**HORSLEY DRIVE BUSINESS PARK –
Response from Western Sydney Parklands Trust dated 12-September 2012**

COMMENTS ON HORSLEY DRIVE BUSINESS PARK – COSTIN ROE
CONSULTING CIVIL ENGINEERING REPORT BY CATCHMENT MANAGEMENT
BRANCH (18 SEPTEMBER 2012)

BREAKLINE - FOR CONTINUATION REFER TO DRAWING DA4-6

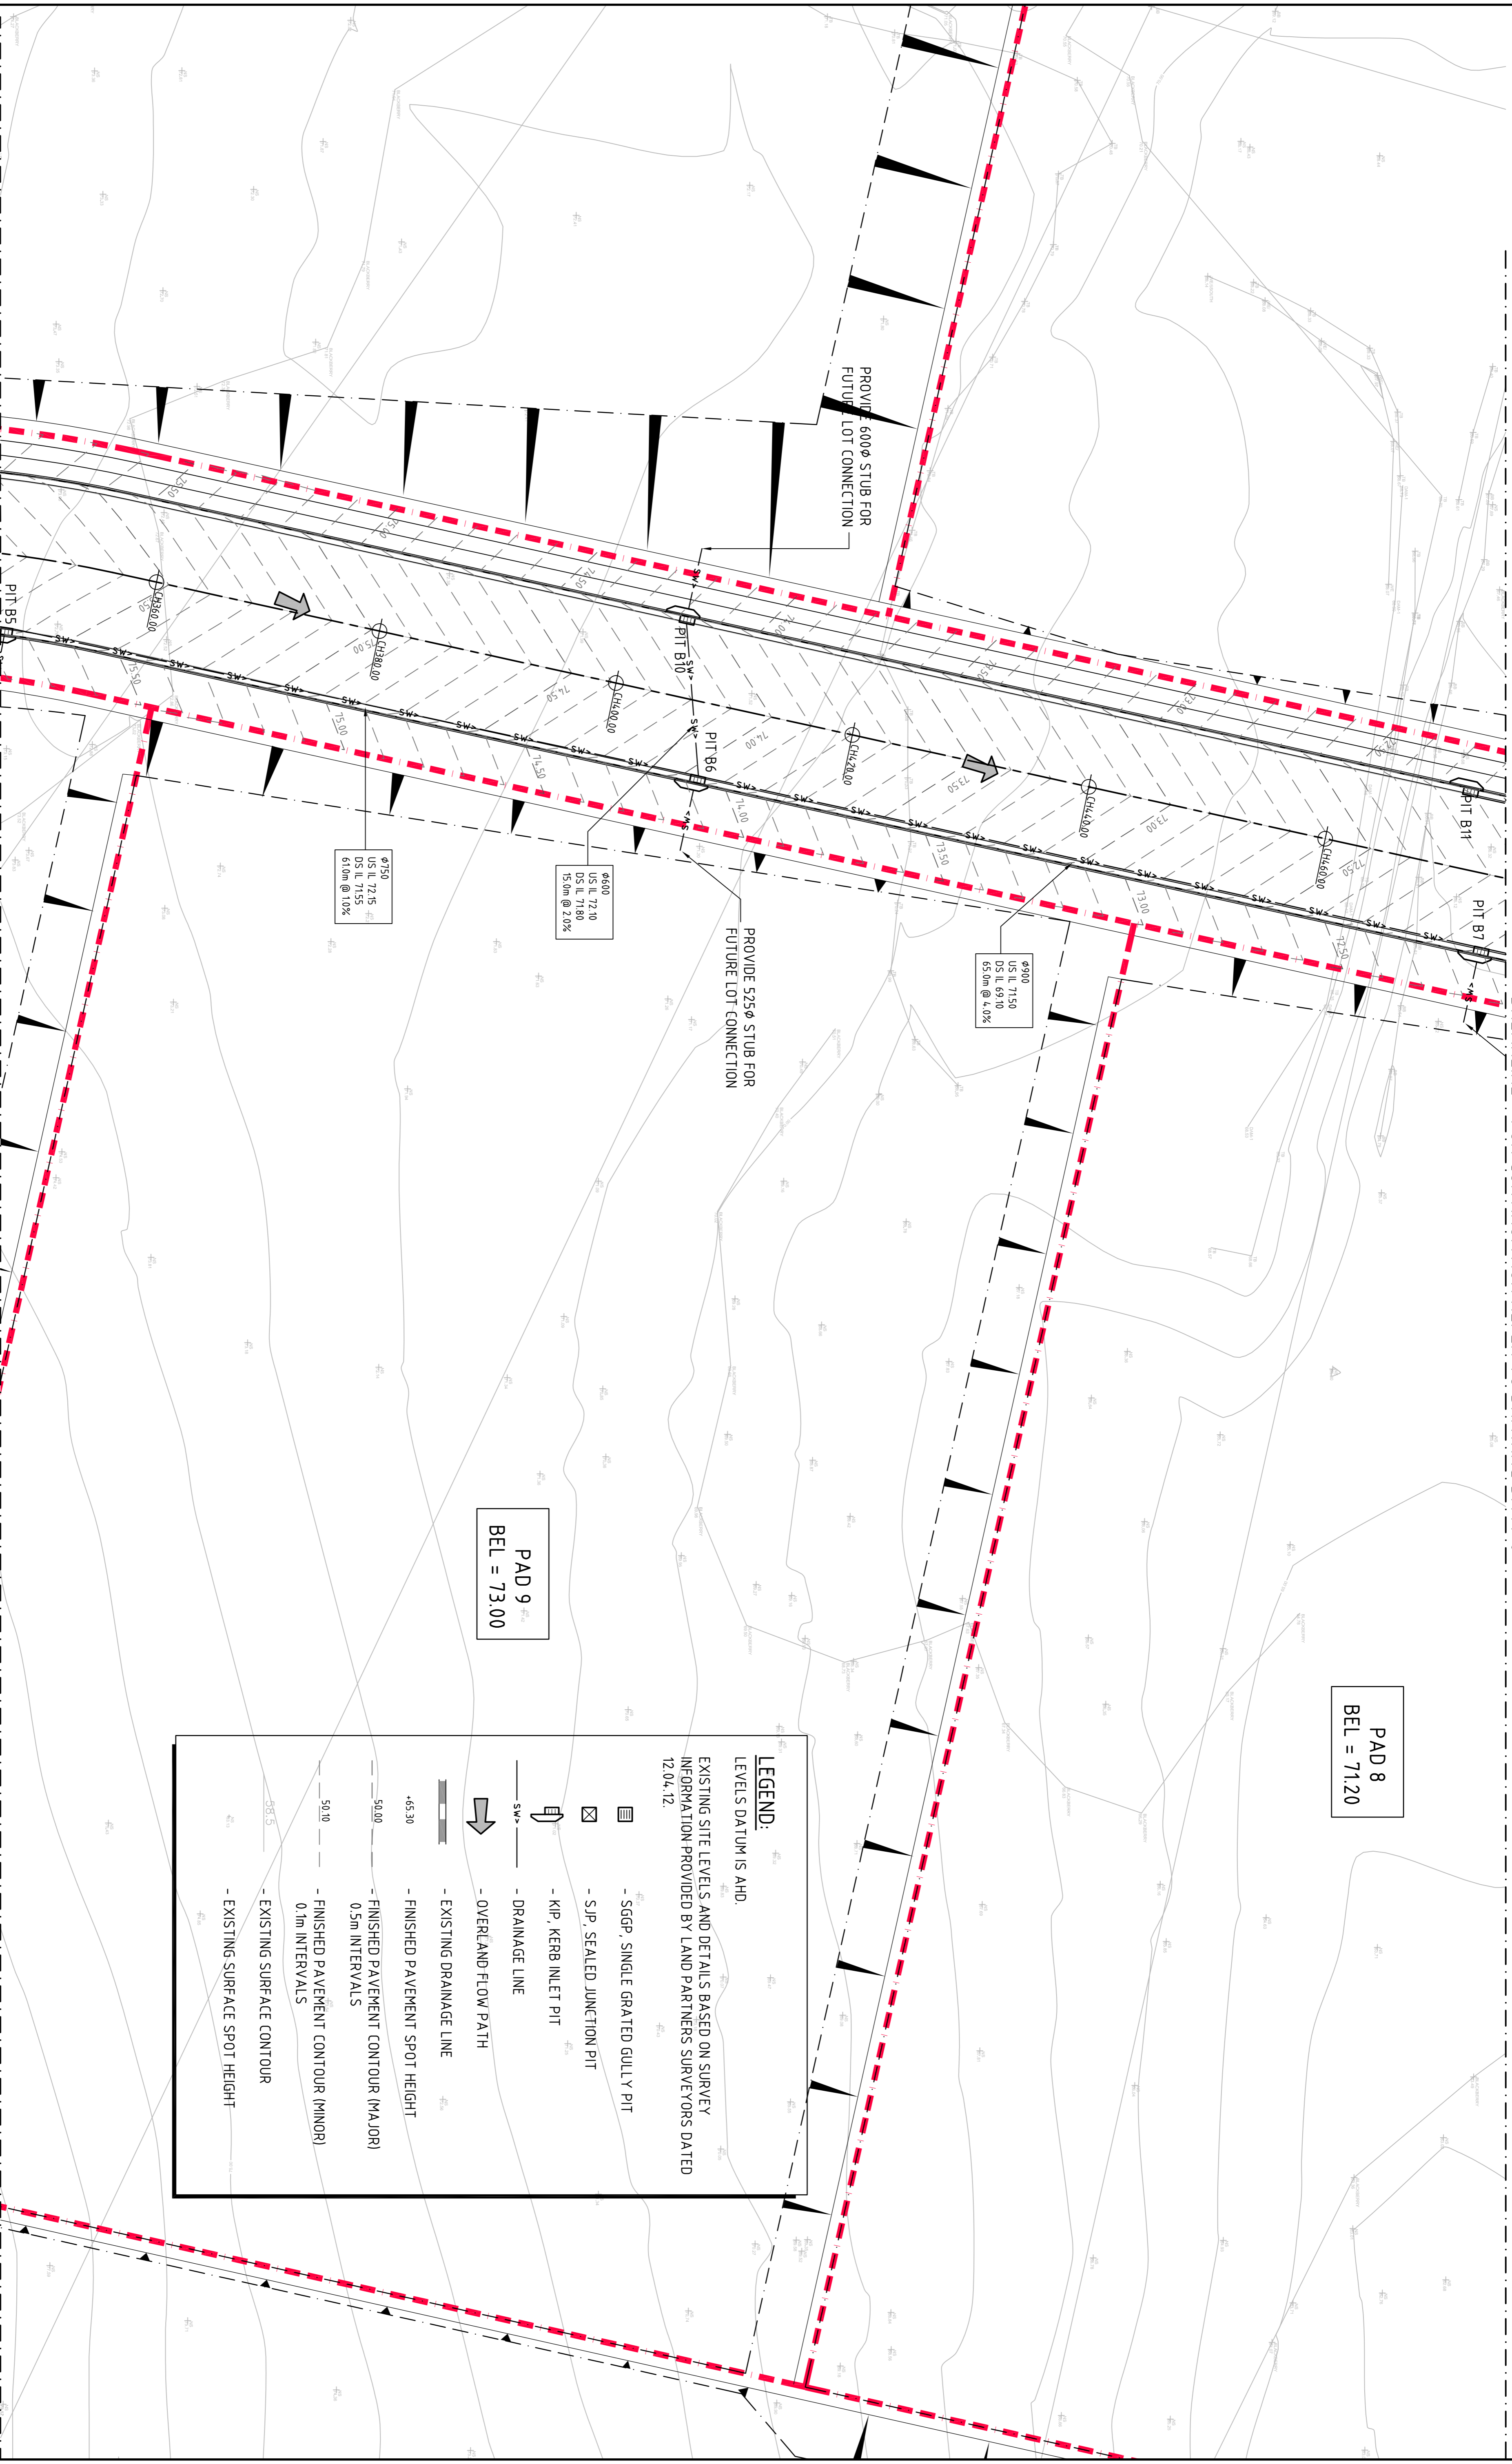
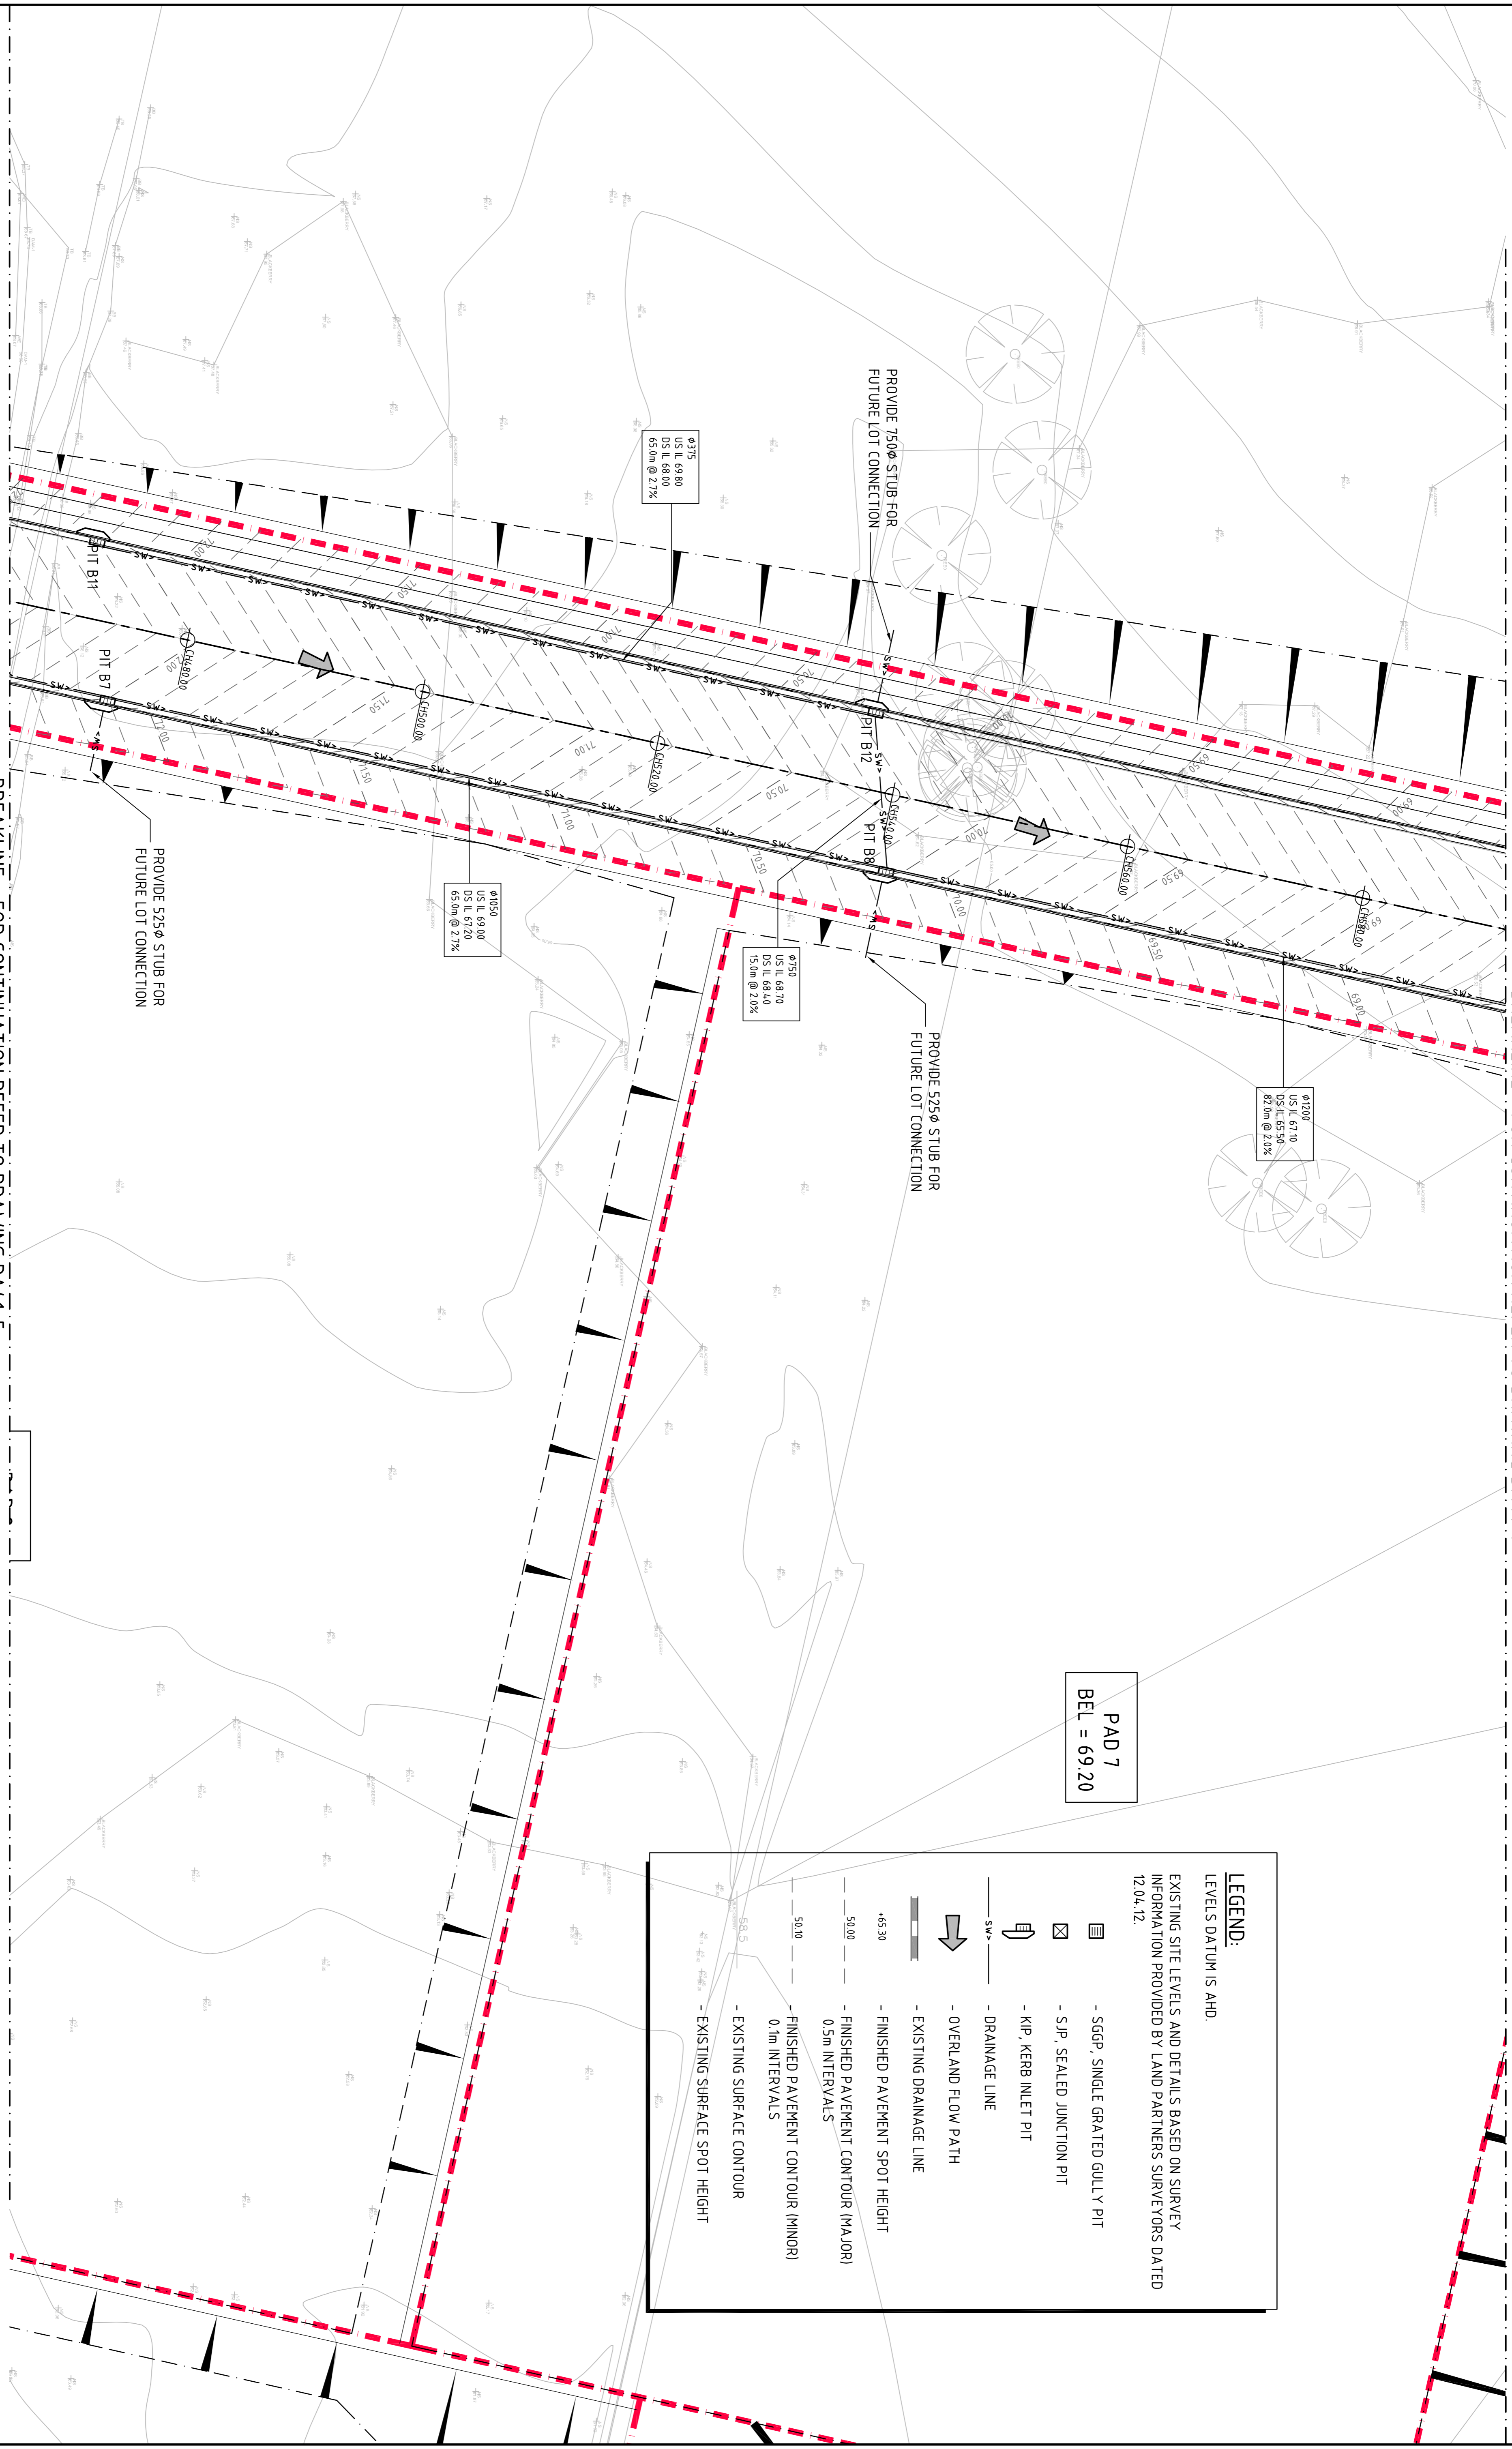
5.4	14	Need to ensure that there is sufficient grade on the overland channel around northern extent of the development. Please provide calculations undertaken to ensure the channel is sufficient.

5.6	16	Details need to be provided with respect to the outlet configuration of both of the basins to ensure they are in compliance with Councils OSD policy requirements.
5.6	16	Do the calculations for OSD include the western undeveloped catchments, as per modelling of flooding at the intersection of Cowpasture Road and Victoria Street.
